**Consultation Response from KC,  
Highways Development Management****2023/92023 Z A Enterprises Ltd, 4, Marsh Gardens, Honley, Holmfirth, HD9 6AP****Change of use from general industry B2 to storage and distribution B8****Date Responded: 28-5-2025.****Responding Officer: Mark Berry.****Responding Ref: 3-40-20.**

Description
SITE PLAN

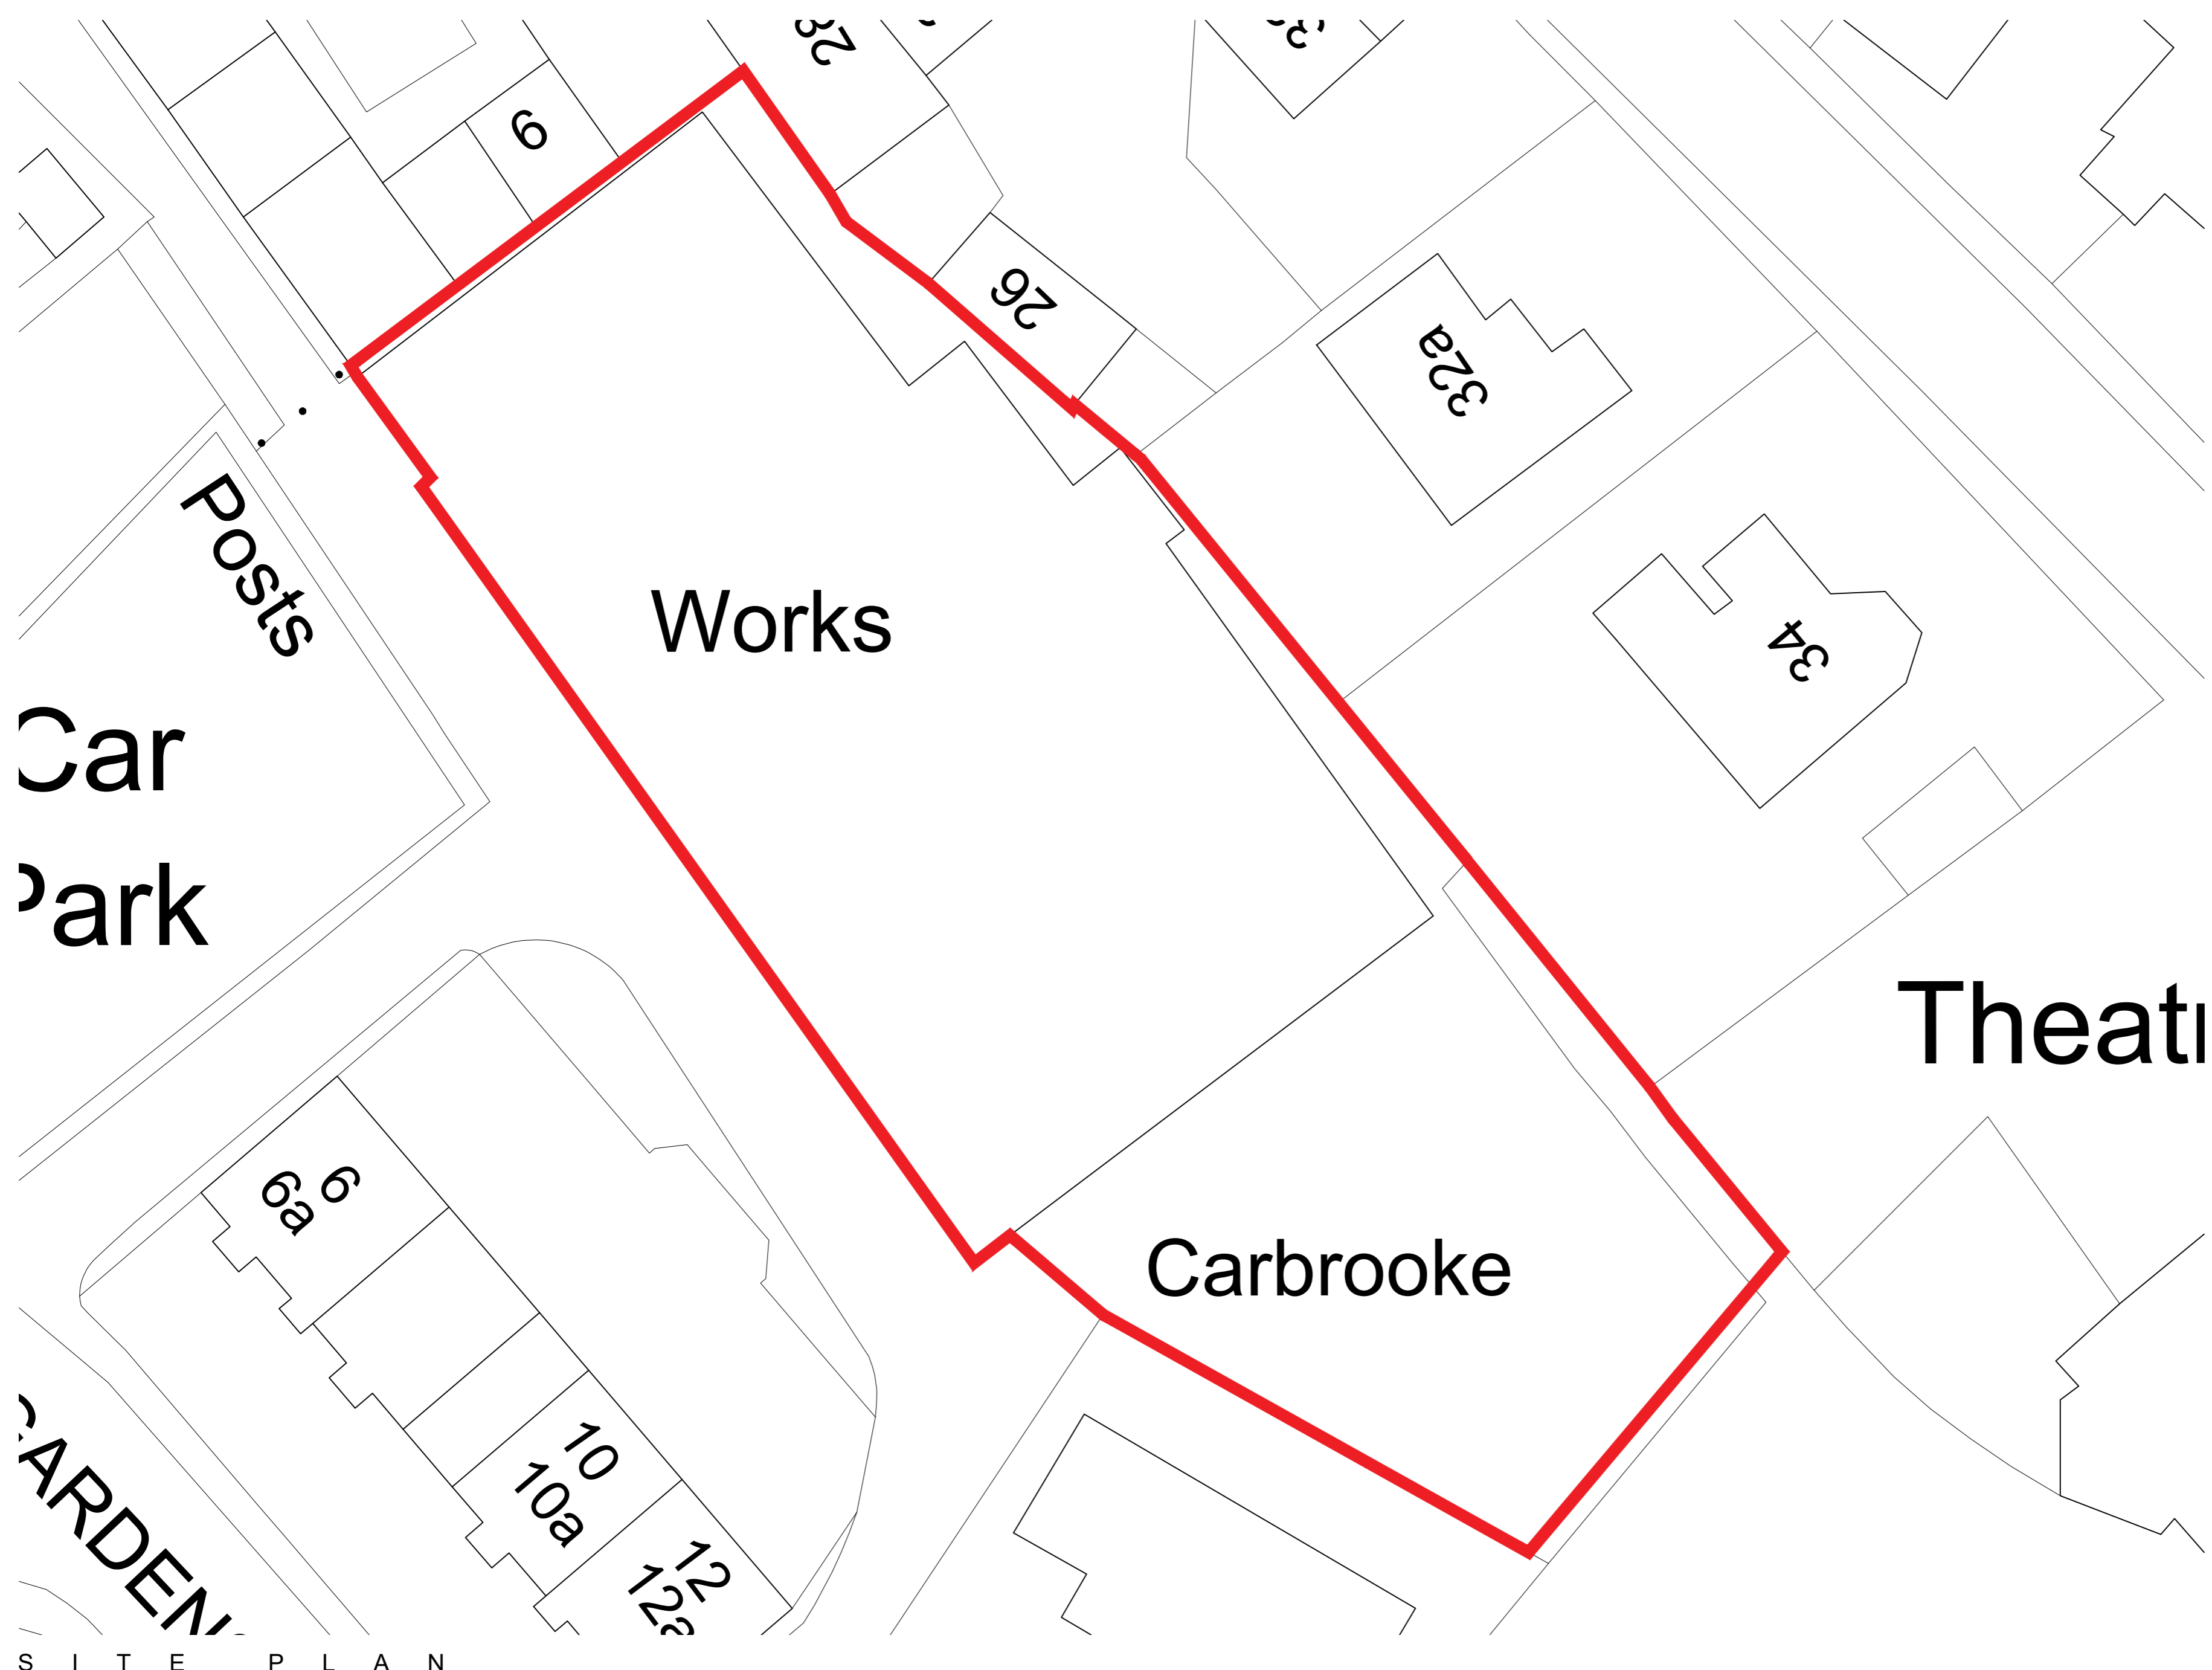
*1, Vehicle swept paths should be provided to demonstrate that the largest vehicle anticipated to visit the site (16.5 m articulated lorry) can enter and exit and turn within the site.*

*2, A plan showing the layout of the proposed parking areas should be provided. Note these should not obstruct HGV turning movements.*

The applicants have provided an Access Statement prepared by Paragon Highways which includes vehicle swept paths for a 7.170 m long vehicle and shows 10 proposed employee parking spaces are not affected by the vehicle turning movements.

These proposals can now therefore be considered acceptable to Highway Development Management providing the applicants are prepared to accept a condition restricting the size of delivery vehicles to that shown on the vehicle tracking swept paths plan or a 3500 kg light goods vehicle.
